Application Ref:	3/2026/0291			 Ribble Valley Borough Council <small>www.ribblevalley.gov.uk</small>				
Date Inspected:	1/5/26	Site Notice:	1/5/26					
Officer:	BT							
DELEGATED ITEM FILE REPORT:					APPROVAL

Development Description:	Variation of condition 2 (Plans) on permission 3/2021/0955 for change of use of land from agricultural to proposed offices. Variation to allow for new windows added to floor plans and elevations.
Site Address/Location:	Old Sawley Grange, Gisburn Rd, Sawley, BB7 4LQ.

drawing: Proposed Floor & Roof Plans

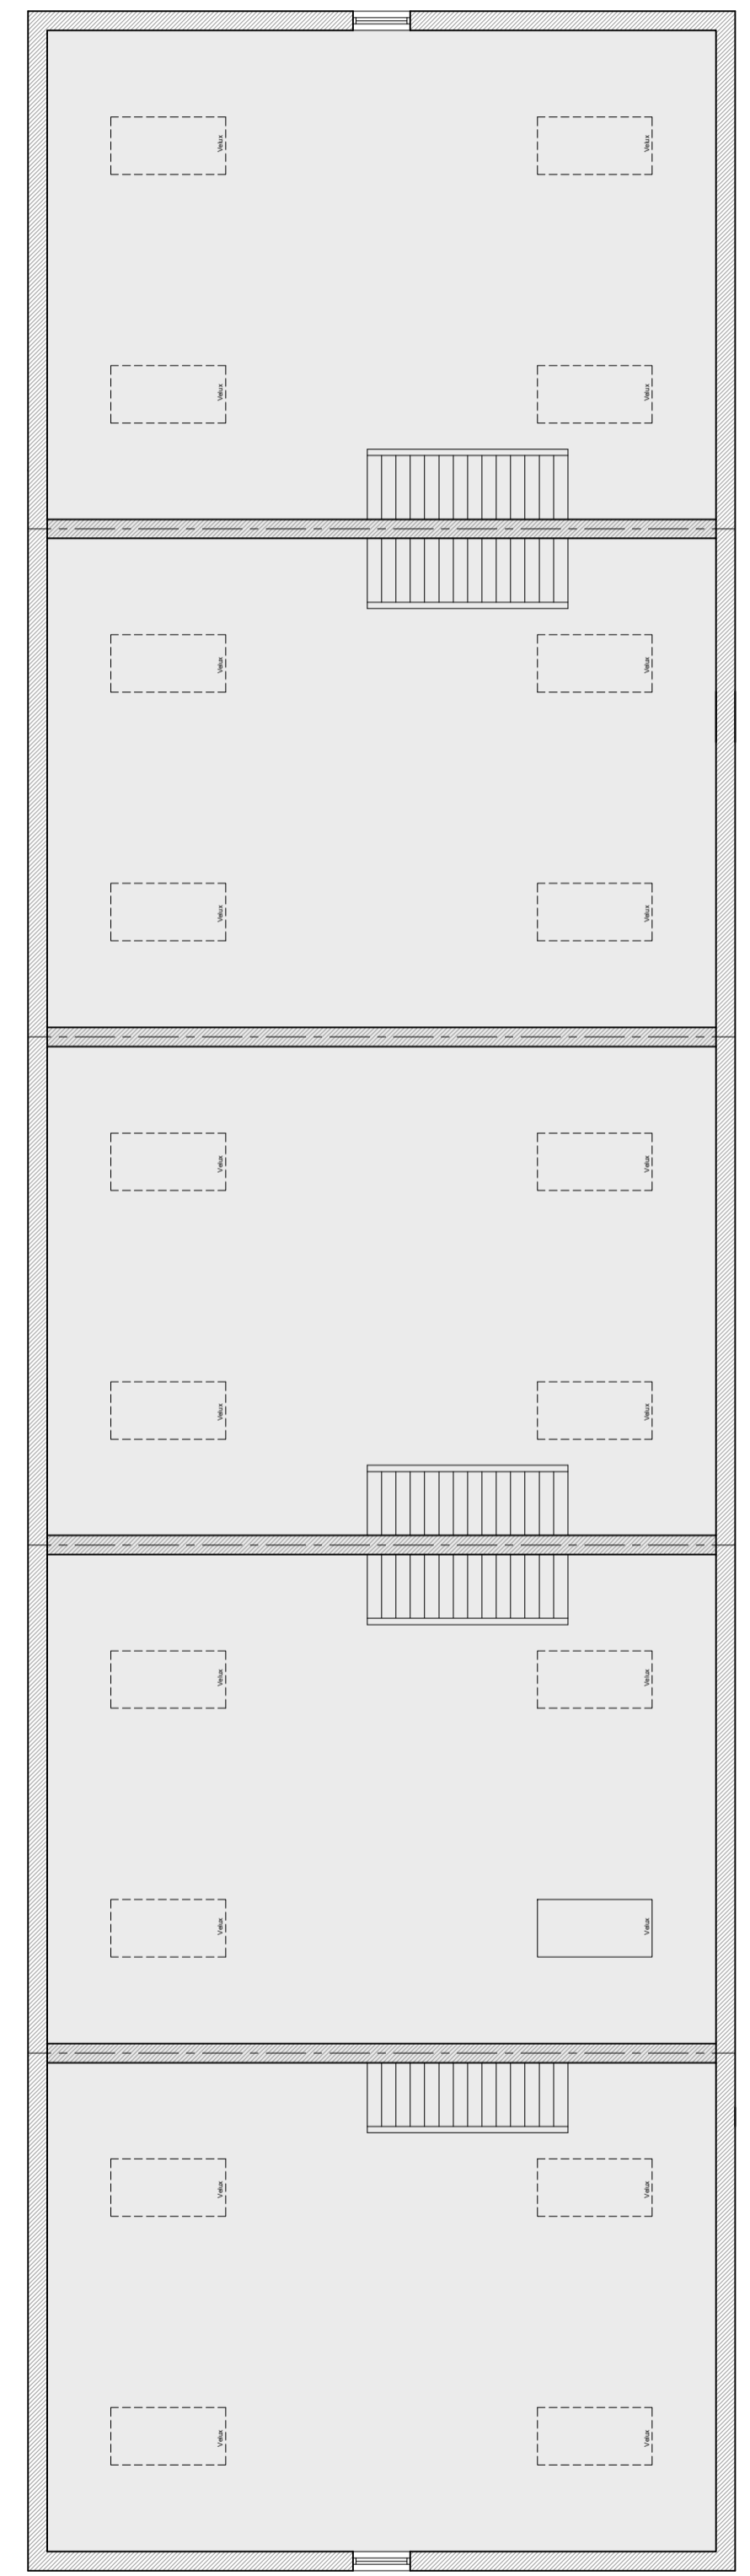
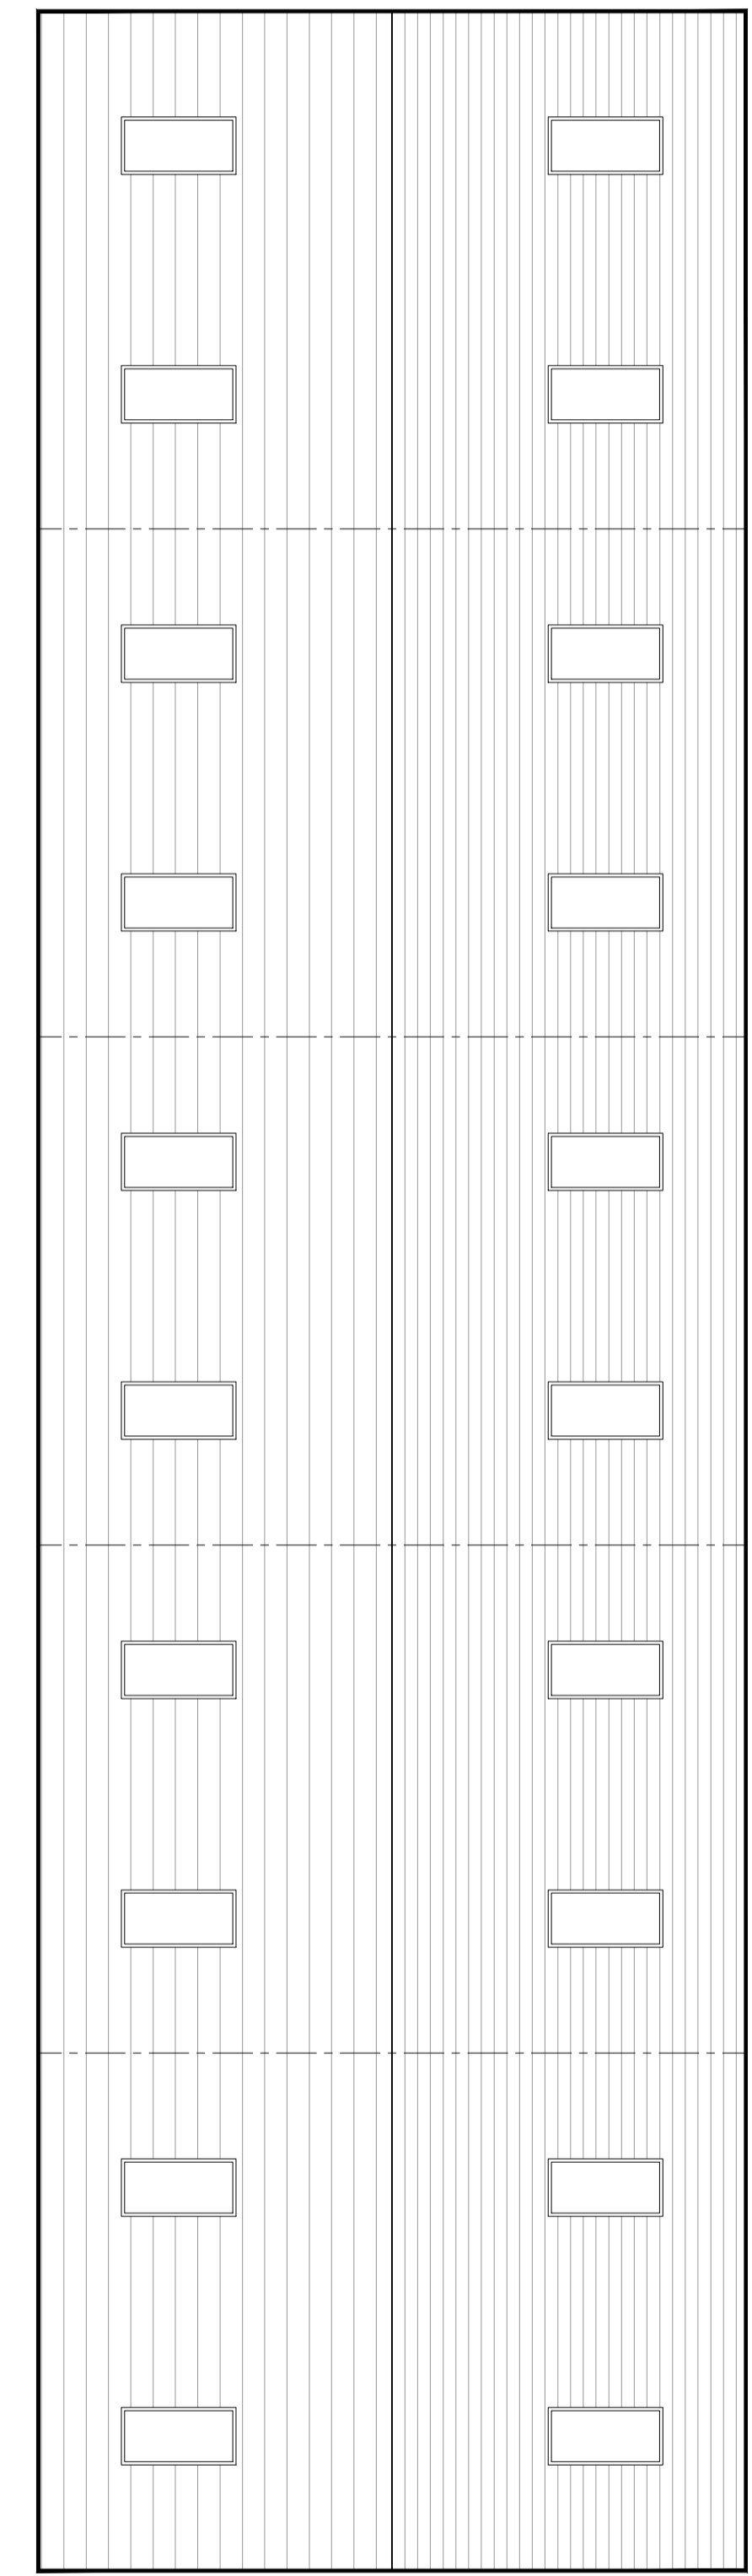
In this instance, the additional window openings proposed for the Western elevation of the office building would provide some additional outlook towards an agricultural building recently converted for residential use however these windows would serve a commercial use with less opportunities for overlooking and there is a 1.5m high stone boundary wall (approved under application 3/2024/0019) which would provide a degree of privacy screening between users of the office building and occupants of the directly adjacent building converted for residential use.

In this instance, the proposed amendment seeks to introduce several new window openings into the Western elevation of the approved office building (incorrectly labelled as the Eastern elevation of the building in the approved elevations drawing for application 3/2021/0955) however the proposed window openings would largely mirror the sequence of fenestration approved for the Eastern elevation of the office building with regards to their spacing, proportionality and quantity, with the proposed amendment resulting in a uniformed development with regards to the cumulative pattern of fenestration within the approved office building.

Taking account of the above, it is not considered that the proposed variations would be harmful to the amenity of any neighbouring residents and would therefore be compliant with the aims and objectives of Paragraph 135 (f) of the NPPF and Policy DMG1.

Consequently, it is considered that the proposed amendment sought would amount to a minor material change to the consent originally approved with respect to design and visual impact and it is not considered that this change would be harmful to the visual amenities of the area. The proposal would therefore satisfy the requirements of Paragraphs 135 (C) of the NPPF and Policy DMG1 of the Core Strategy.
